Lane Cove Council

Redevelopment of Greenwich Hospital (Concept Proposal) at 97-115 River Road Greenwich (SSD8699) Amended proposal.

Ordinary Council Meeting 18 November 2019
COUNCIL SUBMISSION TO DEPARTMENT OF PLANNING ON GREENWICH HOSPITAL
REDEVELOPMENT

1 WINTER SOLSTICE 22nd JUNE 11AM - EXISTING
1:1000

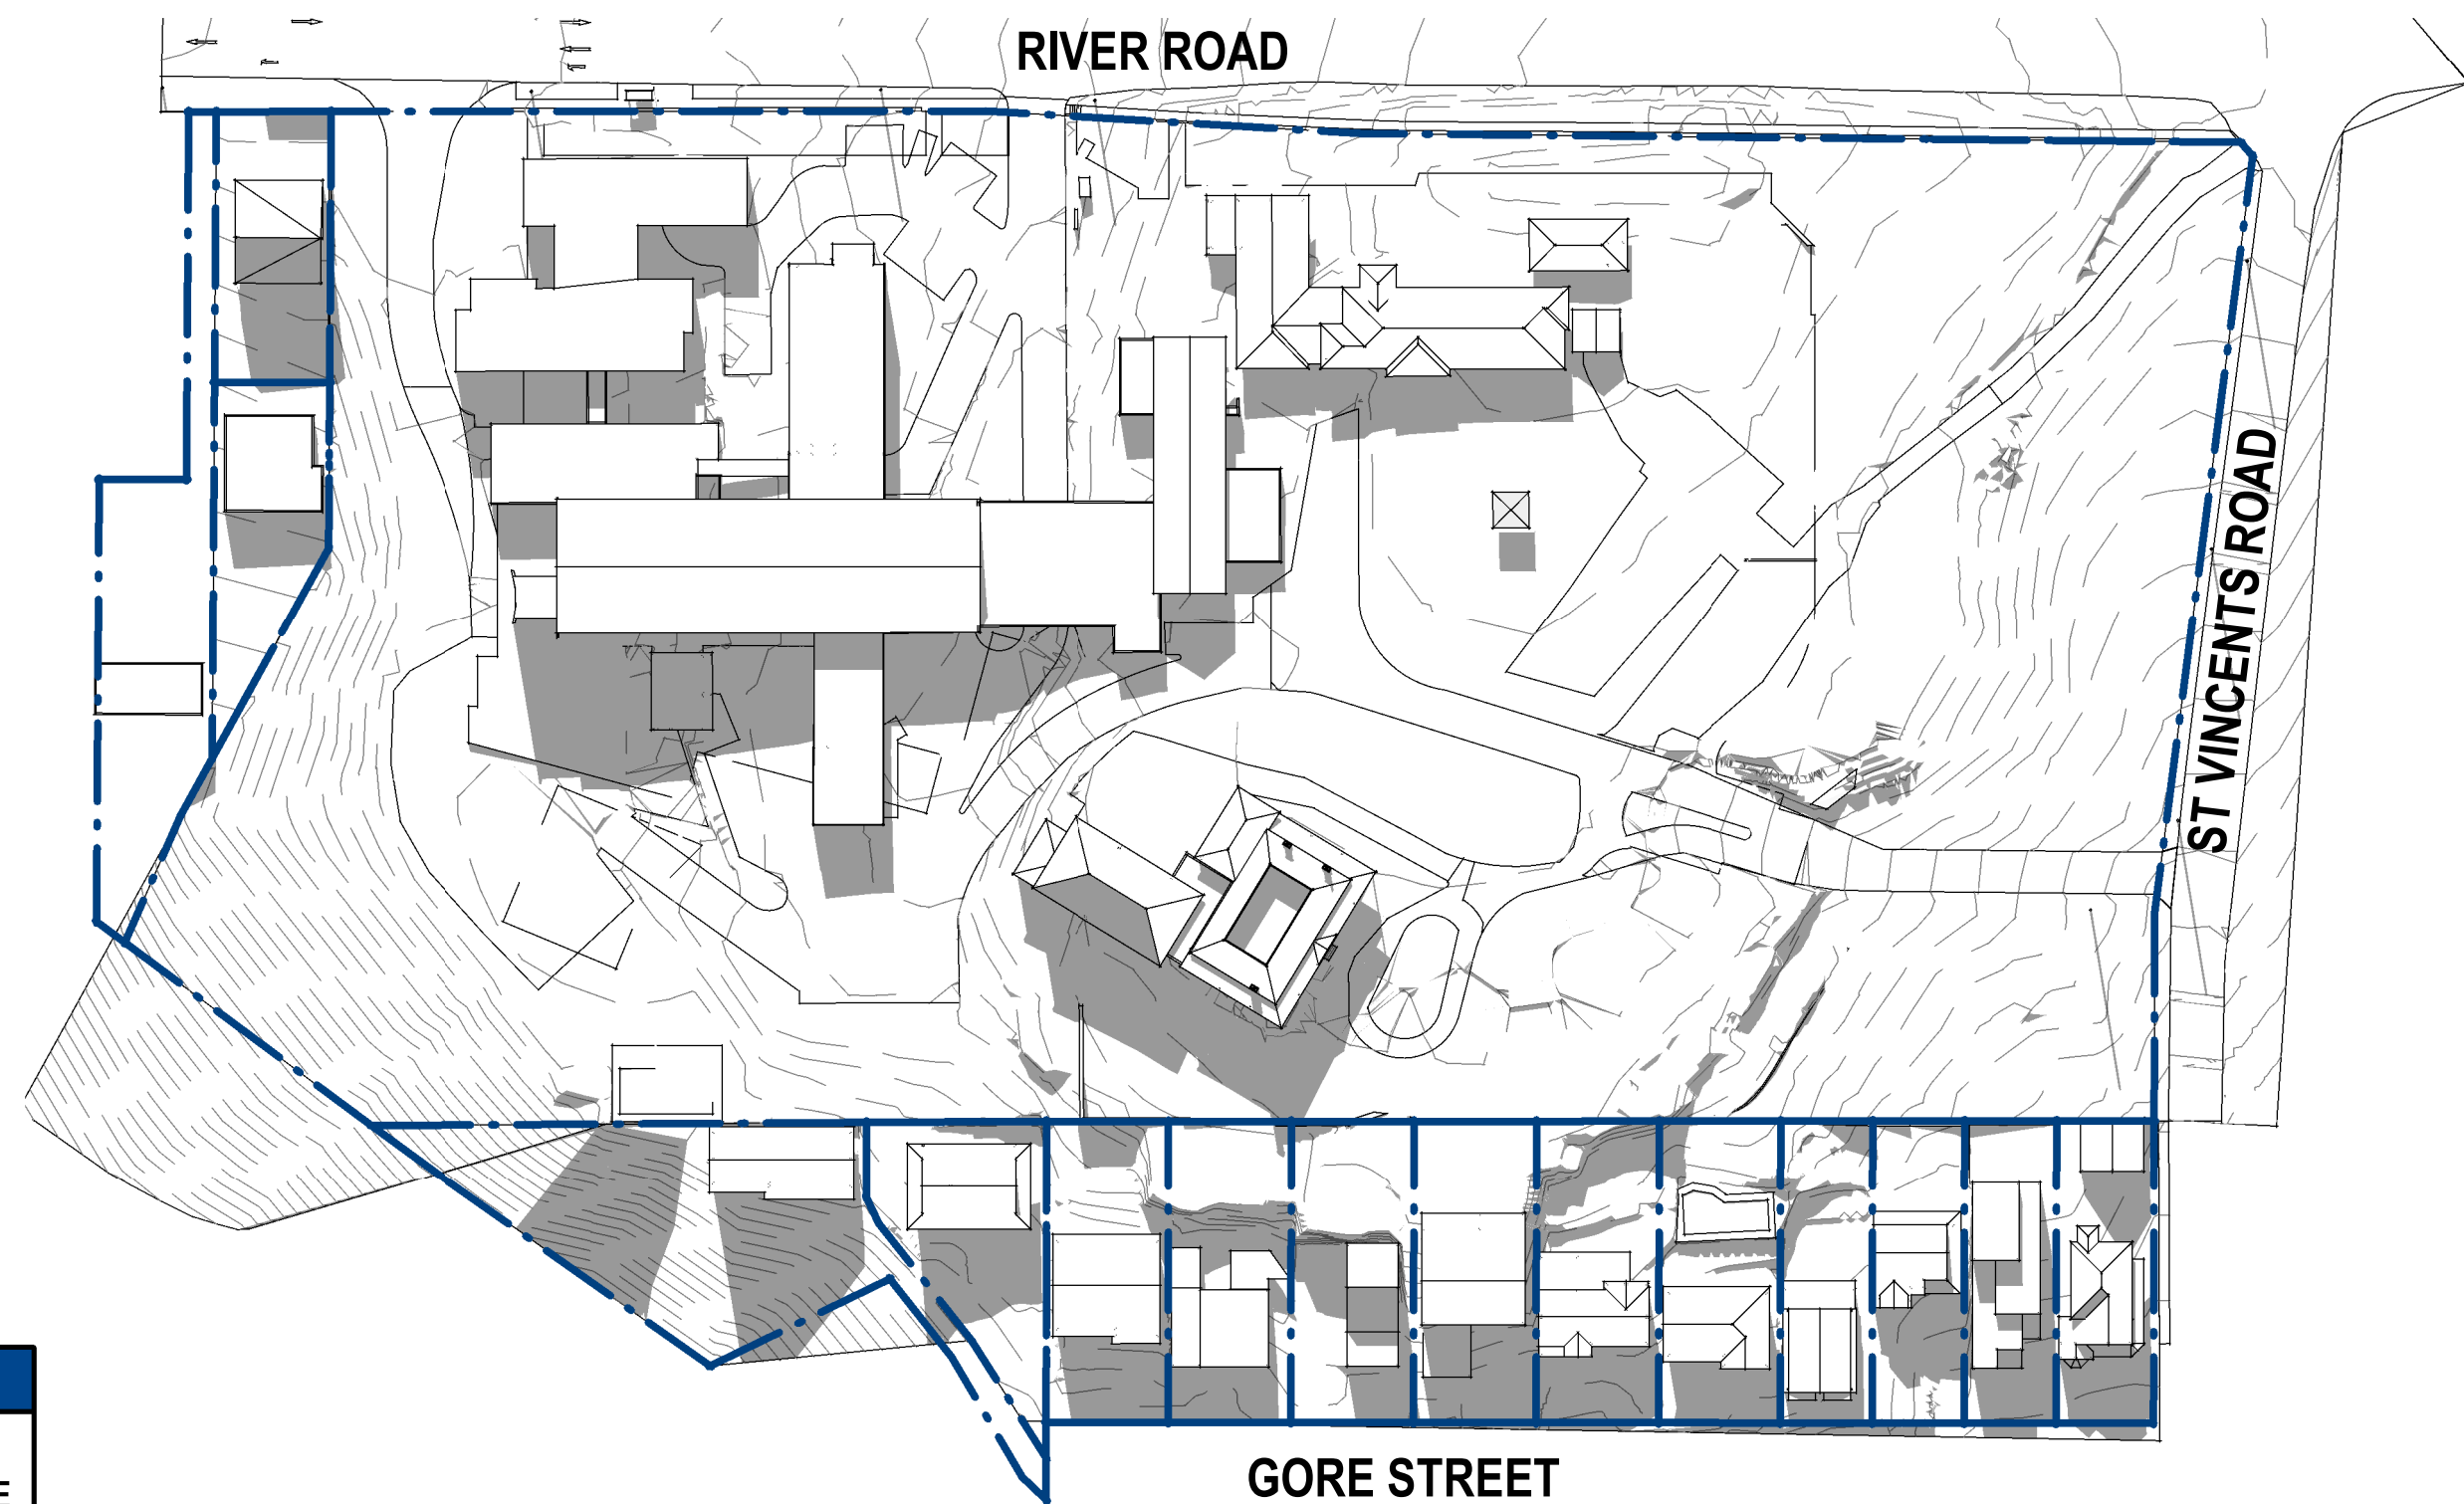
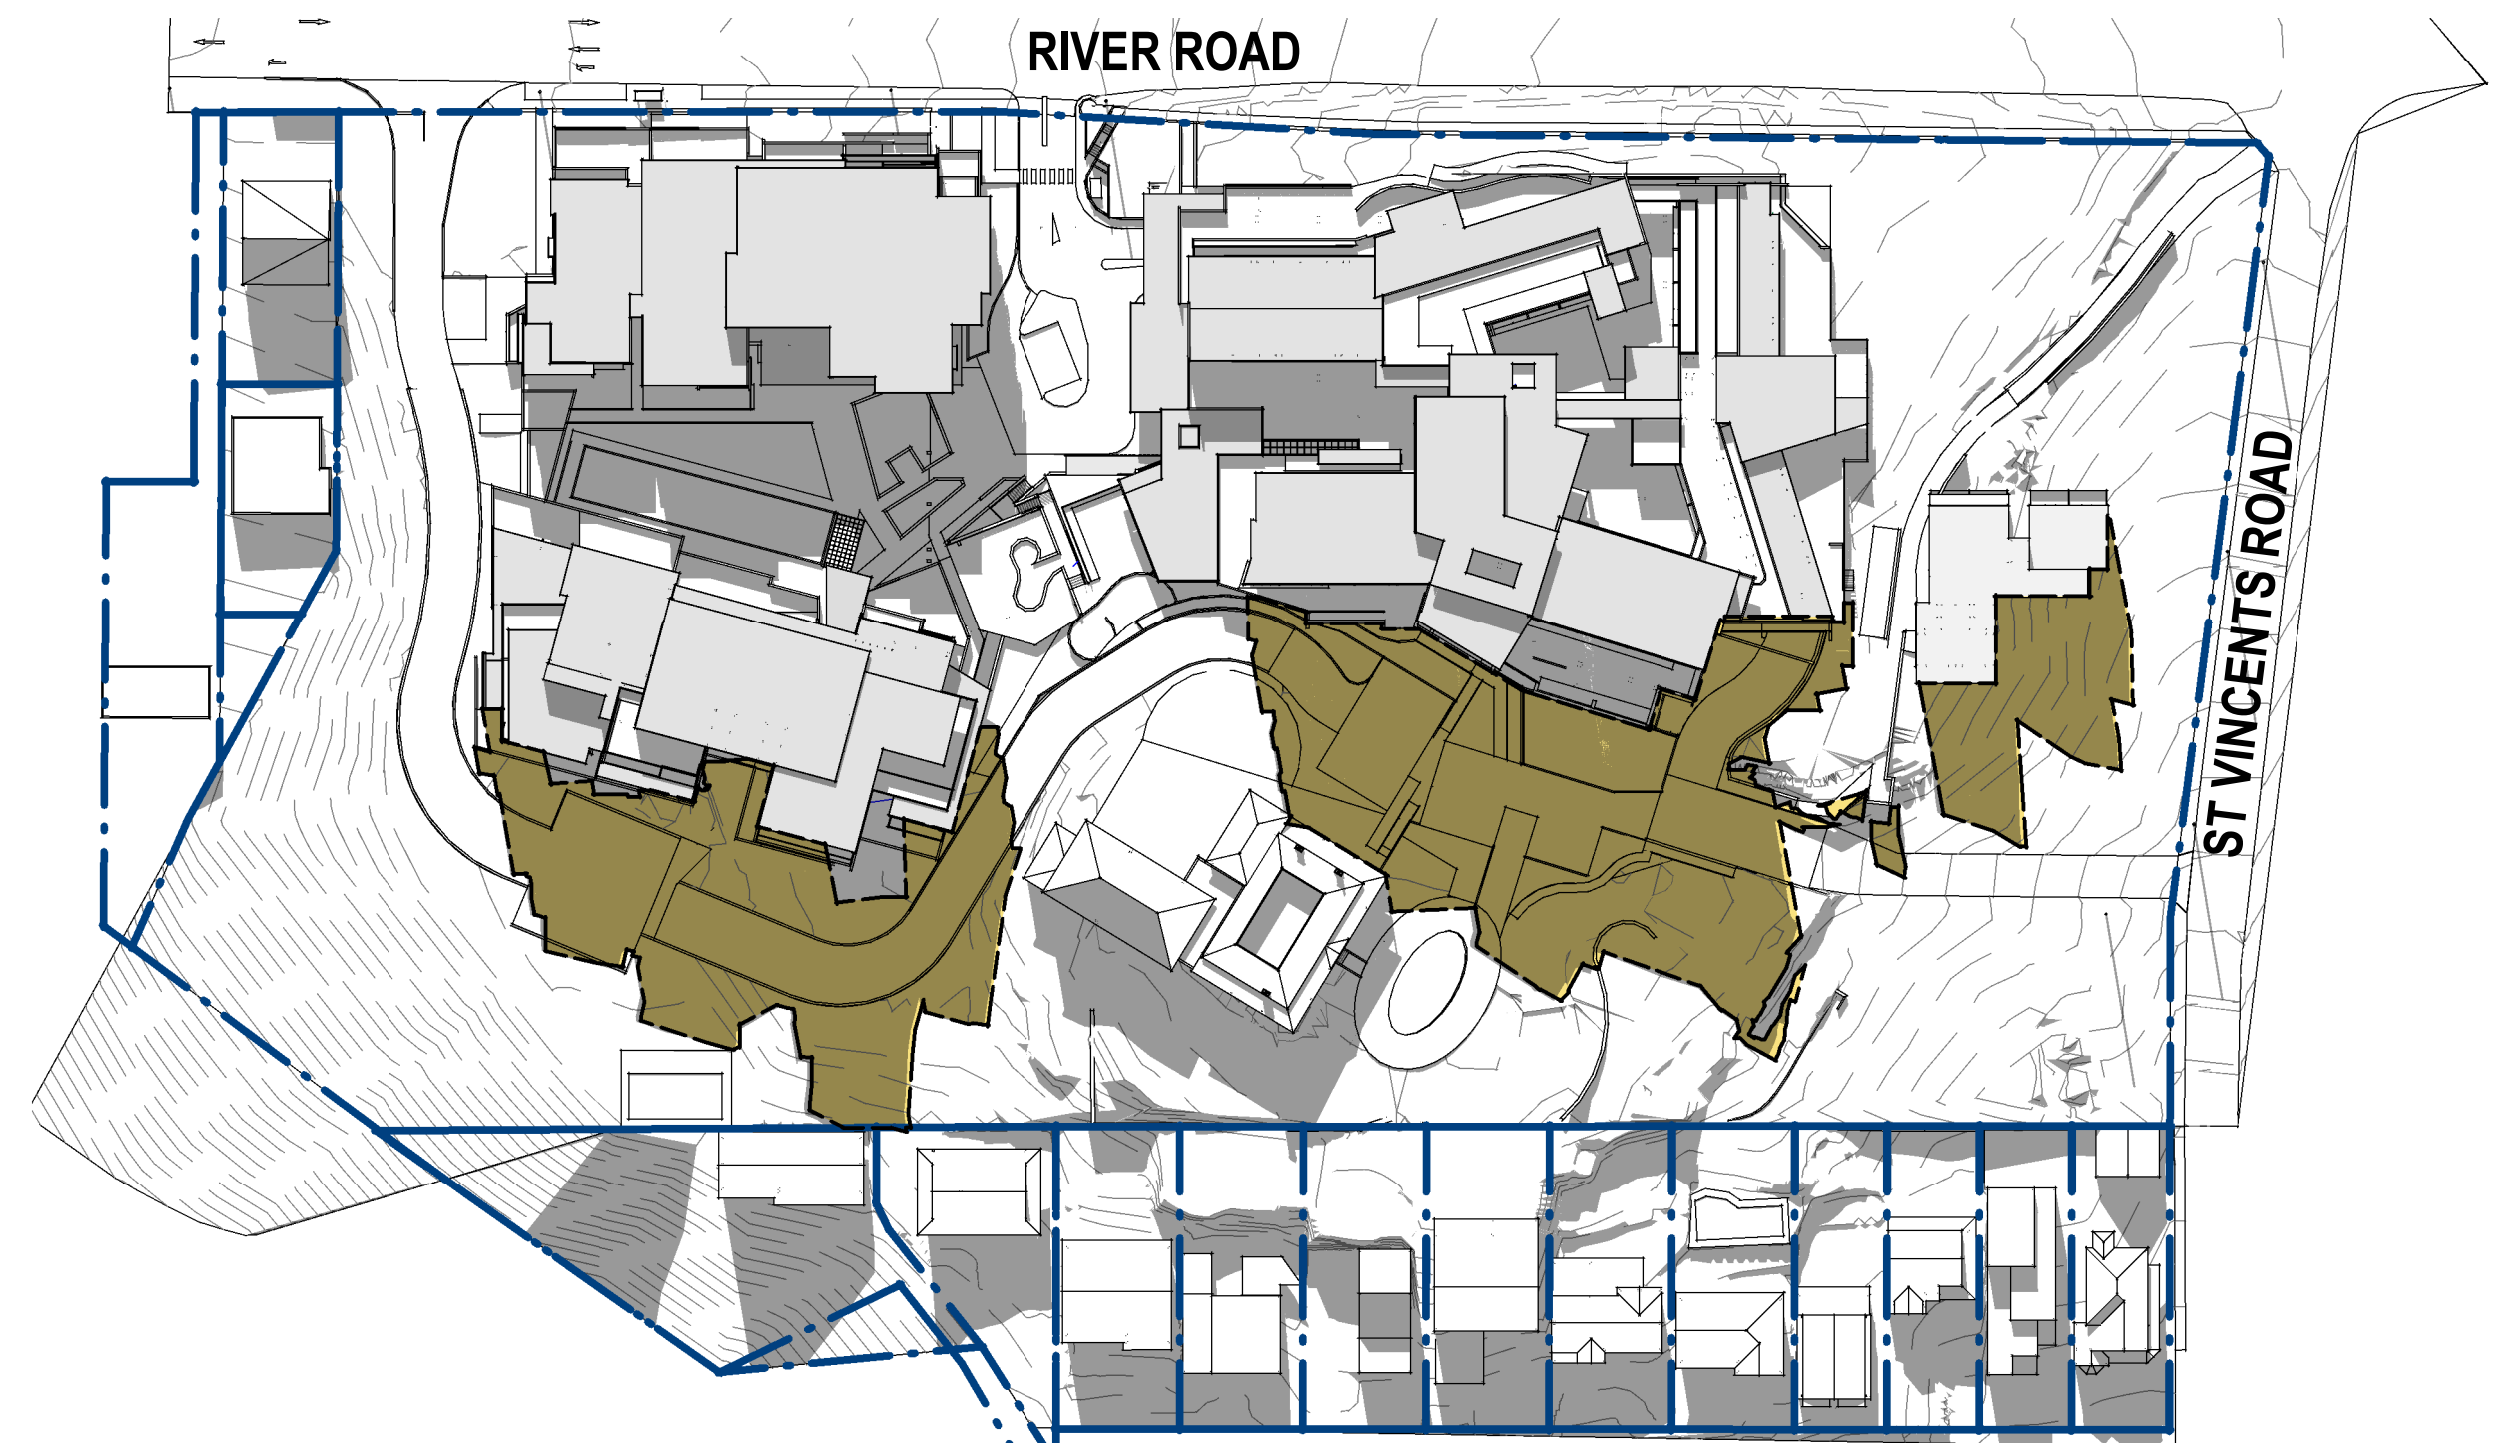
- The contours are incorrect on the south west corner resulting in the shadow analysis being incorrect. The contours are steeper than the survey conducted, which is reflected in the Civil Engineering documentation.
